Application No: AL/35/21/DOC
Site Address: Norton Farm House Norton Lane Norton PO20 3NH
Description of works: Approval of details reserved by condition imposed on AL/34/20/PL relating to condition 5-site plan showing details of hard landscaping.

Thank you for your internet representation made on 9th April 2021 which has been recorded as an objection with the comments as follows:

DRAWING TITLE
EXTERNAL WORKS

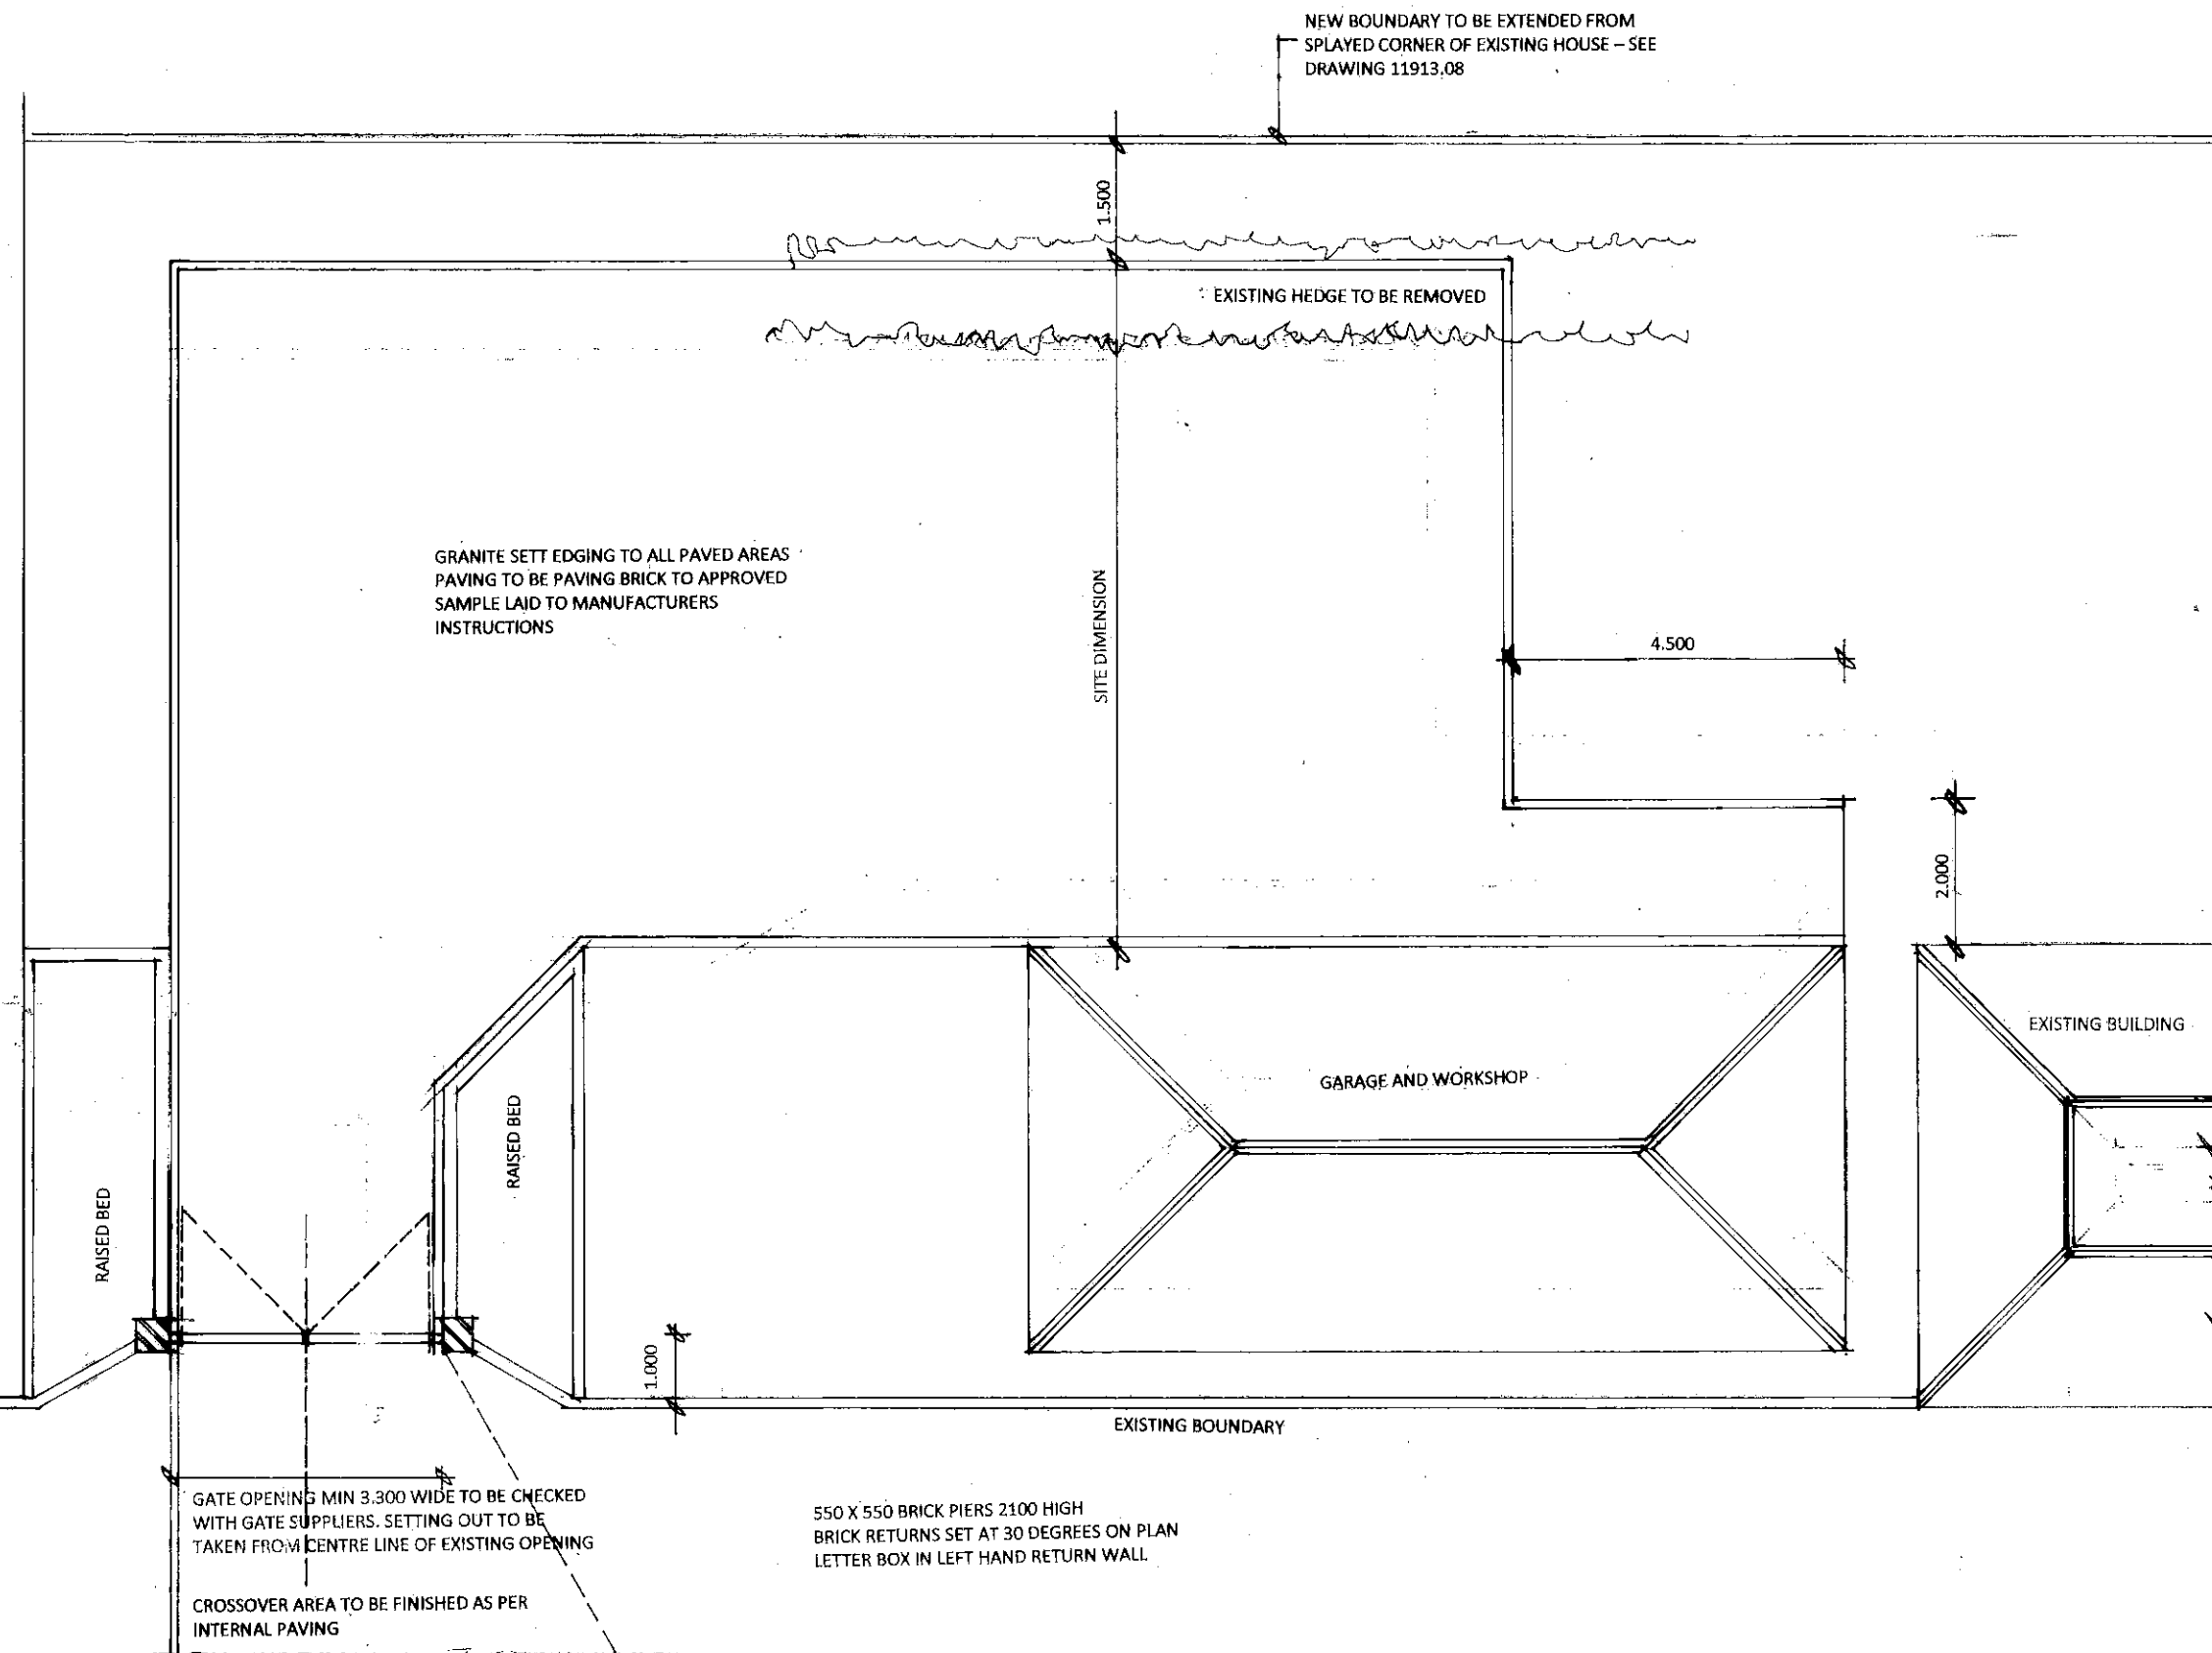
There is no detailed drawing available to see the extent of the driveway . There is an in correct answer to the question can the site in question be seen by public land . We have clear sight and view over the work already been carried out . Mr And Mrs Homer did not have a driveway or clear evidence of a regular used entrance . It is clear that the gateway he has built will be used to serve as a separate access for an annexe he has no planning permission for . The building he has erected so far indicates the intention of being used as a separate dwelling being a brick block construction with a separate driveway . The planning permission allowed for a wooden oak framed with larch featherboard finish for a carport What was wrong with the previous access he had ? It is clear that he will use this access as a main use for a separate dwelling which should not be allowed . We have clear sight from our property and would be happy for the council to view to see for themselves . His property is a grade 2 listed building and in a conservation area and The building and driveway if allowed to continue will set a precedence for us all to build what we like and that would have a detrimental affect on this area which should be conserved in the appropriate manner.
